City of Portland, Maine - Building or Use Permit Application

Permit No: 02-0154 Issue Date: MAR 4 2002 CBL: 076 A013001

Location of Construction: 26 Frederic St Owner Name: Ajar-akol Pio Okuc Owner Address: CITY OF PORTLAND Po Box 8208 Phone: 856-5640

Proposed Project Description: Build 4' x 20' deck and 7" x 11" stairs. FIRE DEPT: [X] Approved [] Denied INSPECTION: Use Group: R-2 Type: SB BOCA-1599

26 Fredrick Street

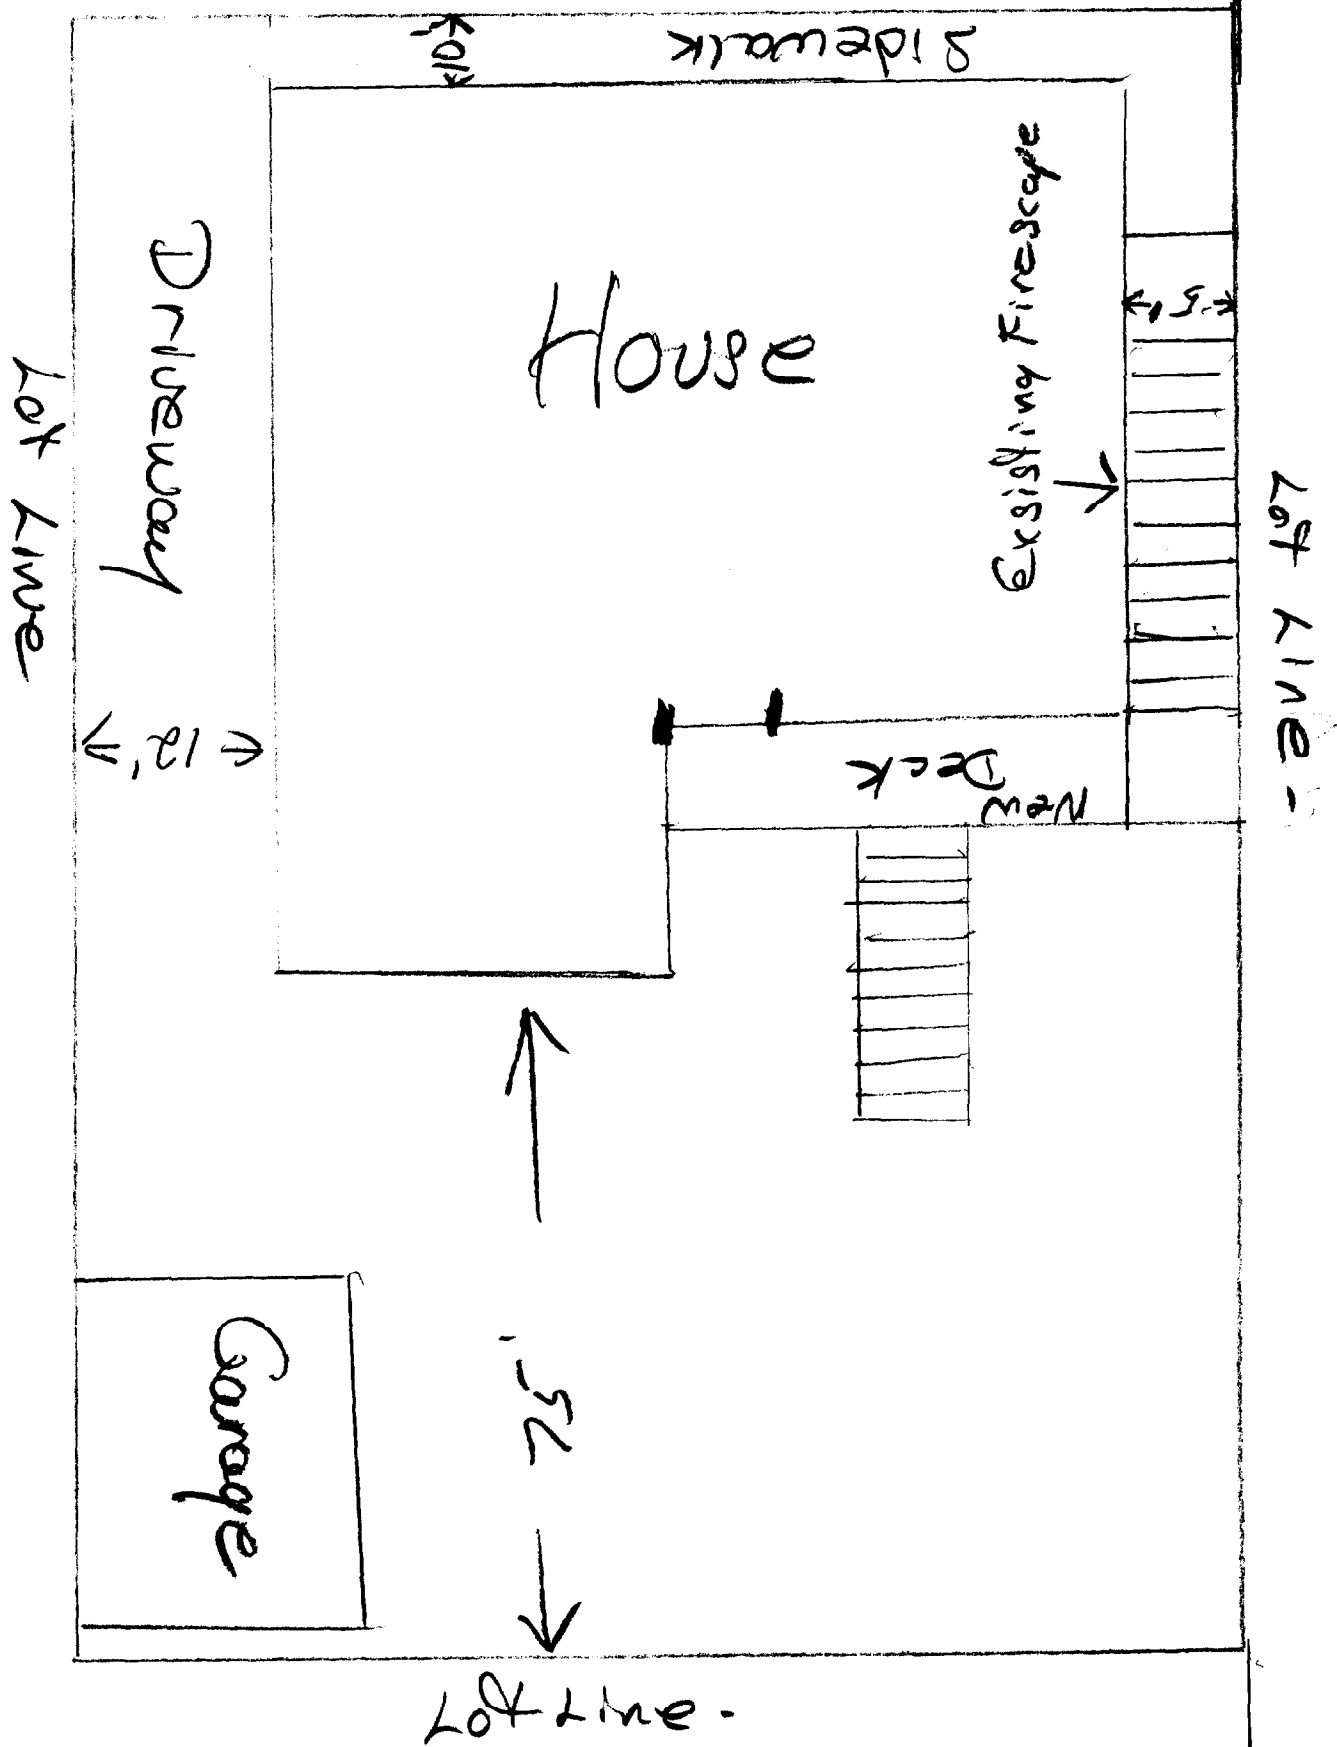
? what is this?
 ? This?
 3/6/02 contractor
 left a message
 that there was 50'
 to the rear property line

Comments: 26 Frederic St
2/26/02 requested setback from edge of stairs to rear property line. - visited property to view existing fire escape
3/6/02 - 50' plus to rear property line from edge of stairs.

Back of 26 Fredrick St.
Portland

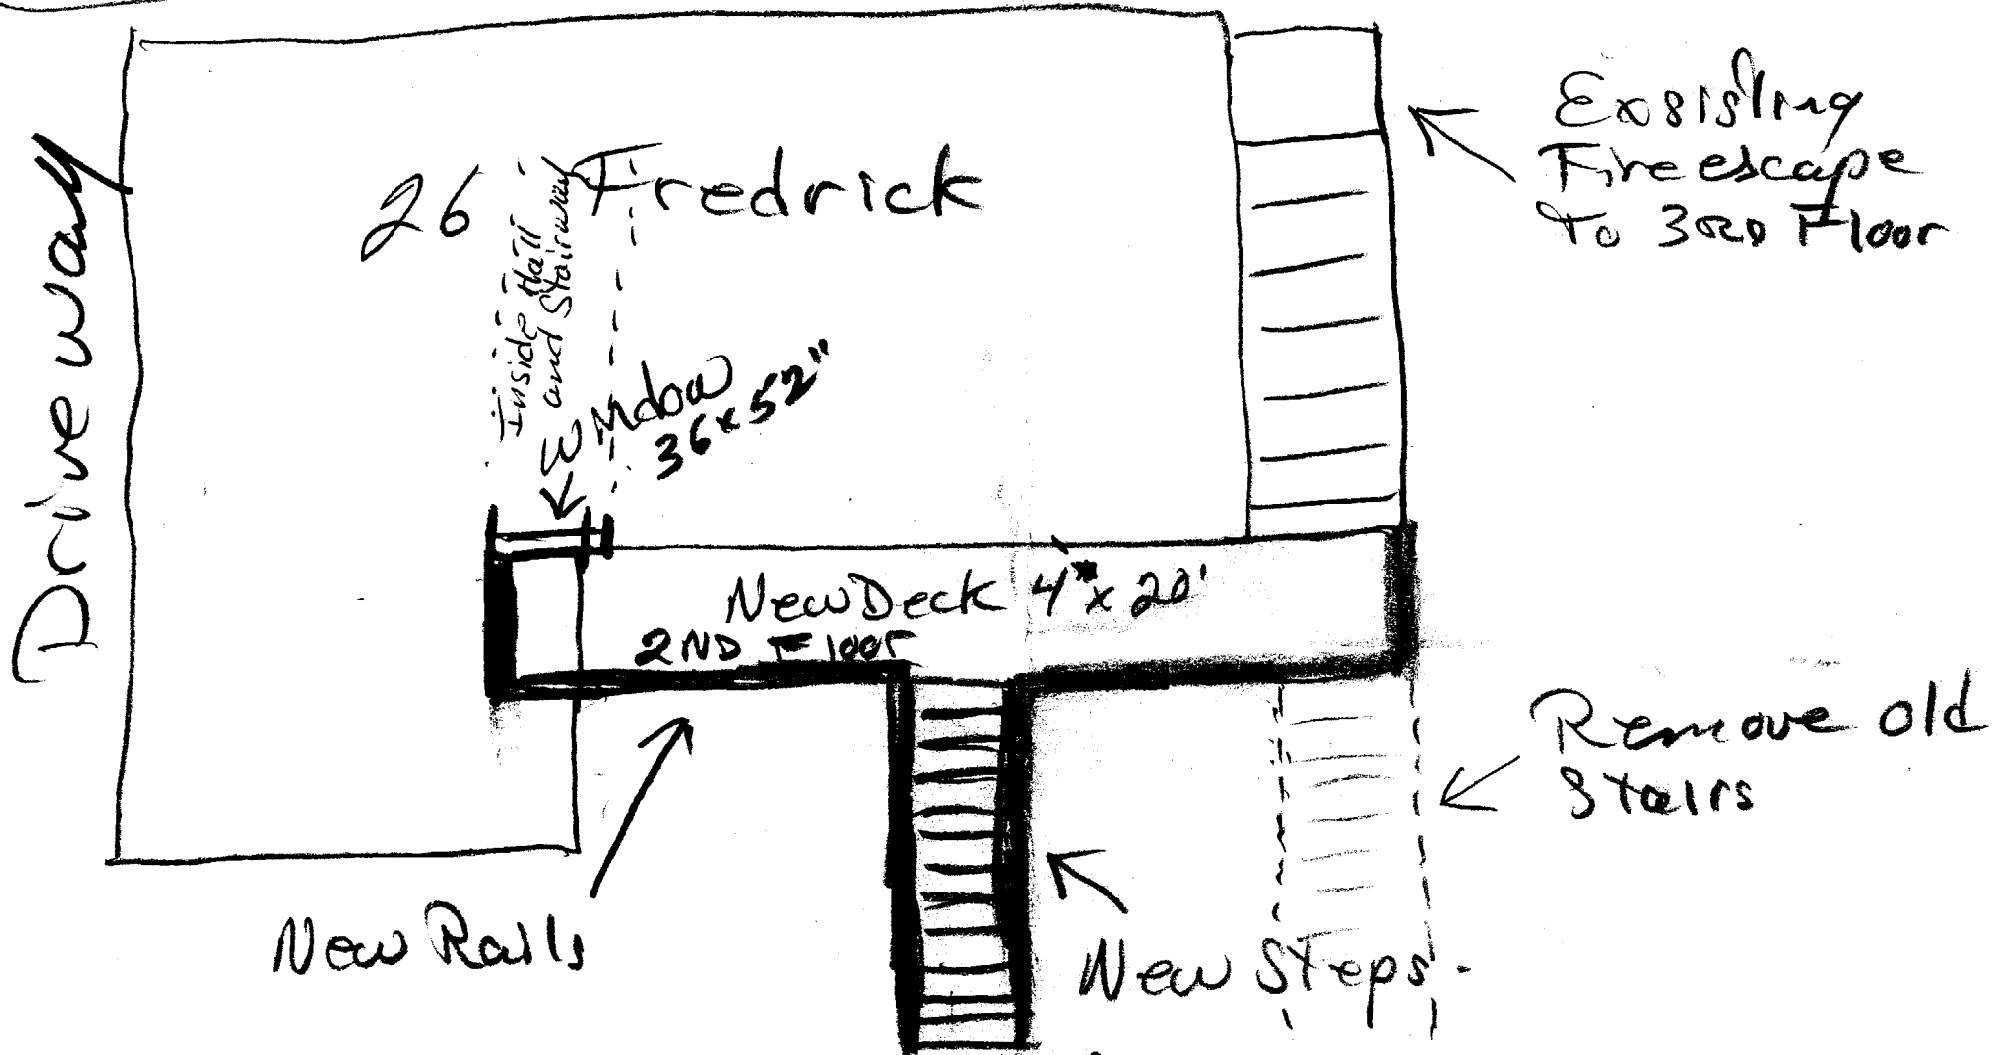
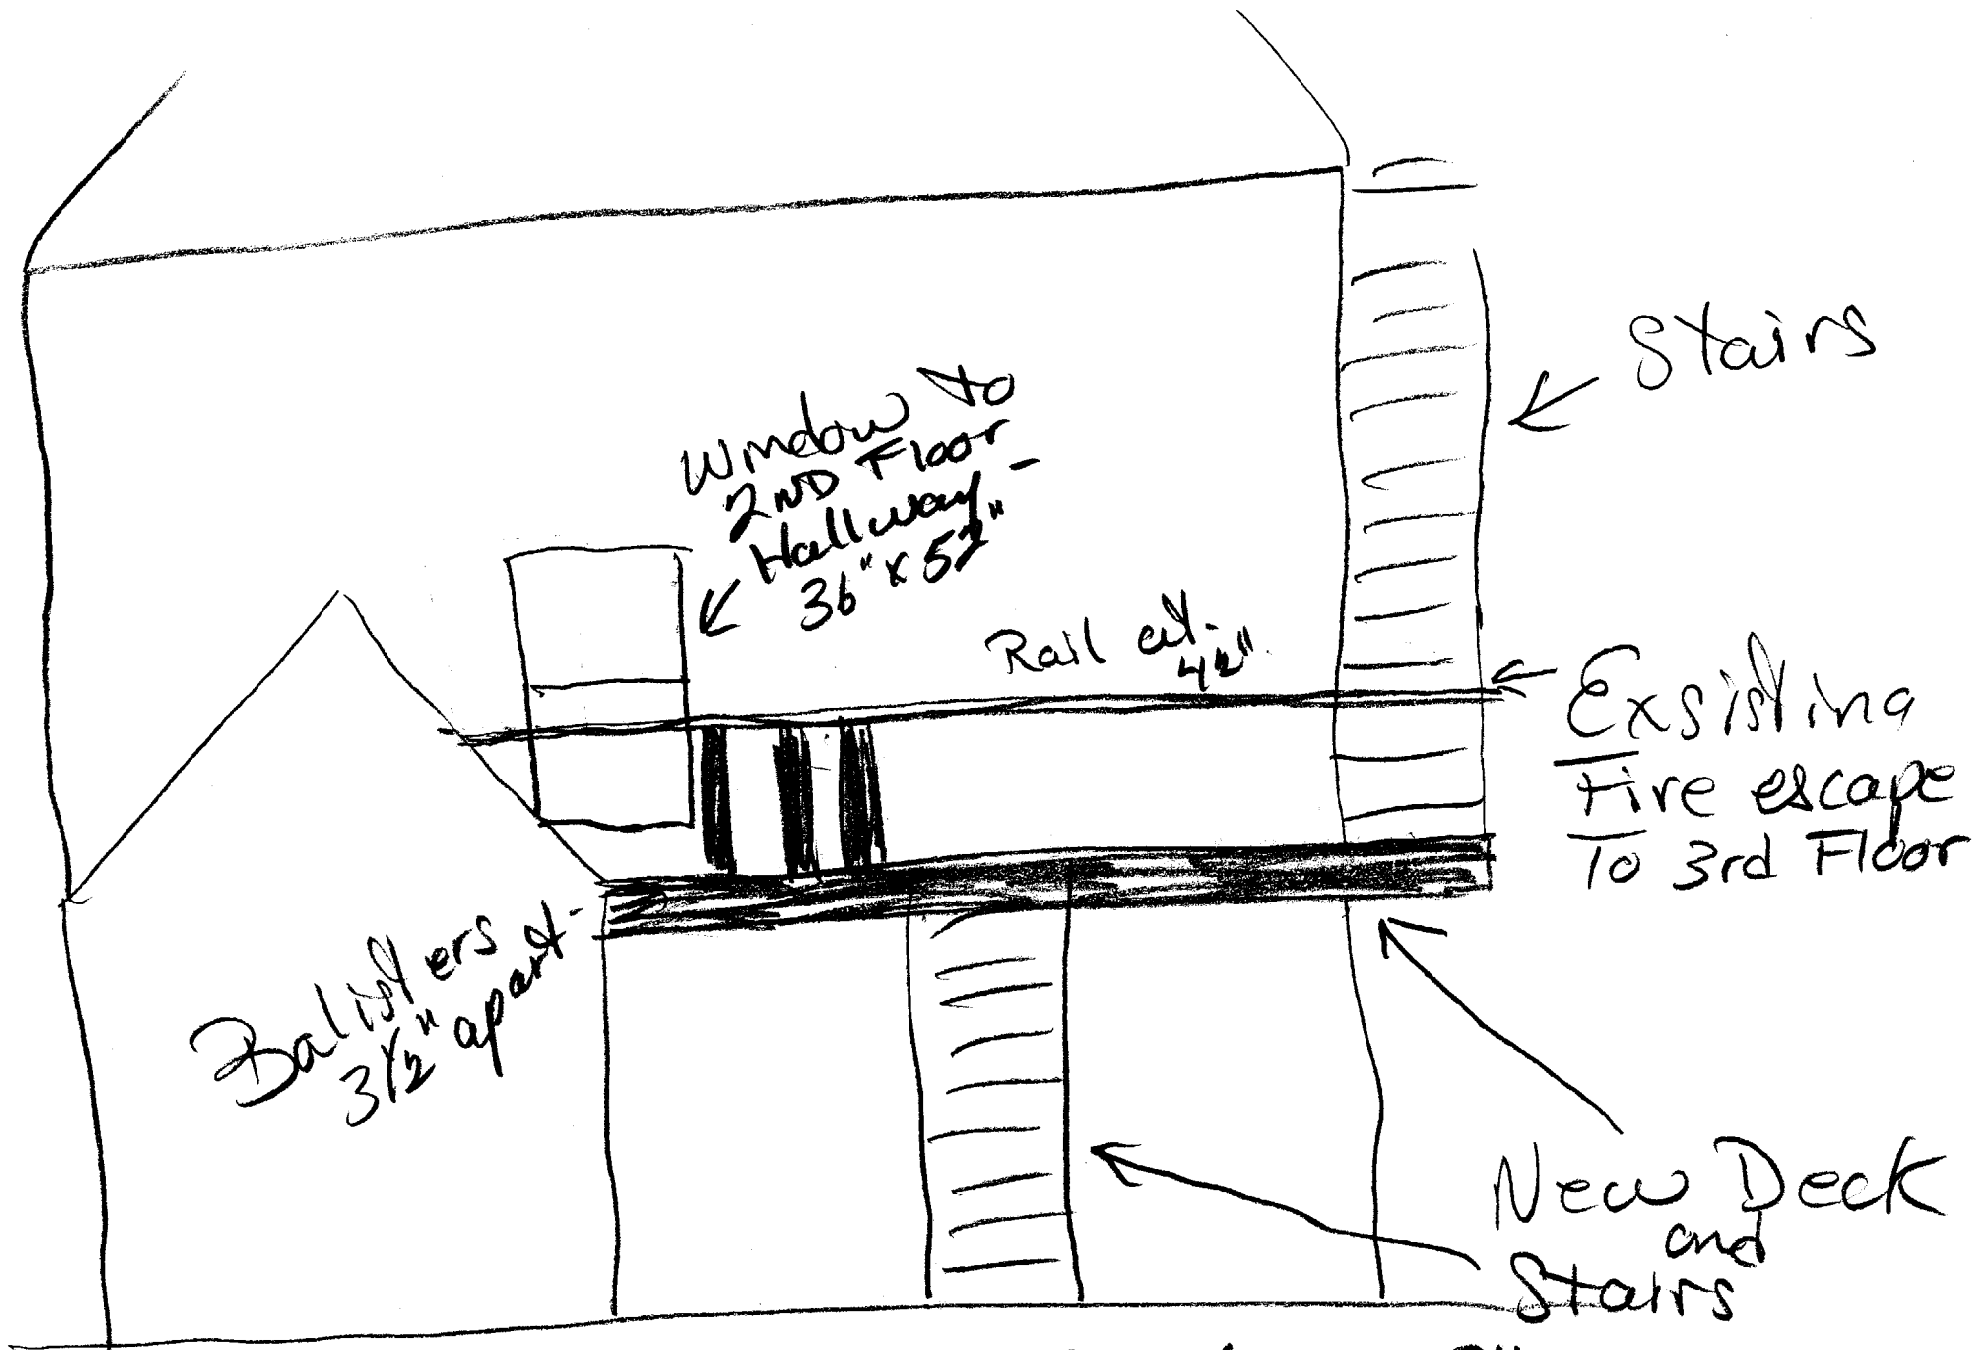
- ① Girder? - 2 - 2"x8" - 6'-0" span - OK
- ② Posts + sawn tubes? - 4"x4" ~~posts~~ + bolted to house
- ③ Guardrail system w/handrail - 42" high w/graspable handrail
- ④ Riser boards? - will have riser boards.

Risers Riser 6 3/4" (top) to 8" (Noet)

Treads Average 8 3/8" net
 spots w/ owner on site

Note: Both Tammy & I went over Tread/Riser issue at different times w/ Raymond Dupuis.
 See Specs submitted on pg 3 of Plus

Went over all of the above w/ Raymond Dupuis - OK to issue. 4PM.
